Rezoning Petition Review

Date of Review: May 20, 2020 (*Revised June 19, 2020*)

Rezoning Petition #: 20-67

Location of Property: Approximately 2.96 acres located on the south side of Mecklenburg Ave, west of Belvedere Ave and east of Winter St.

RZ-4

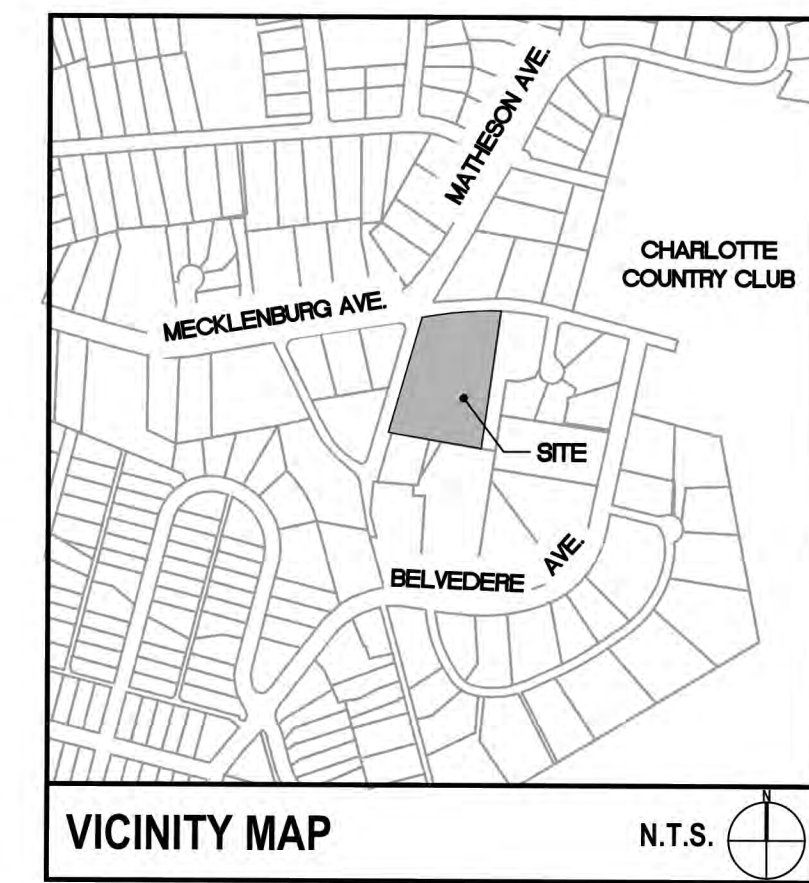
Please include the following note under Environmental Features. *For adjoining parcels receiving storm water discharge the petitioner shall analyze the adequacy of the existing storm water conveyance on the adjoining parcels to the downstream channel (identified by the SWIM/PCSO buffer west of Peppercorn Ln). If the existing storm water conveyance on the adjoining parcels is found to be inadequate, the Petitioner shall make a good faith effort with the property owner(s) to improve the storm water conveyance or mitigate the storm water discharge onto the adjoining parcels.*
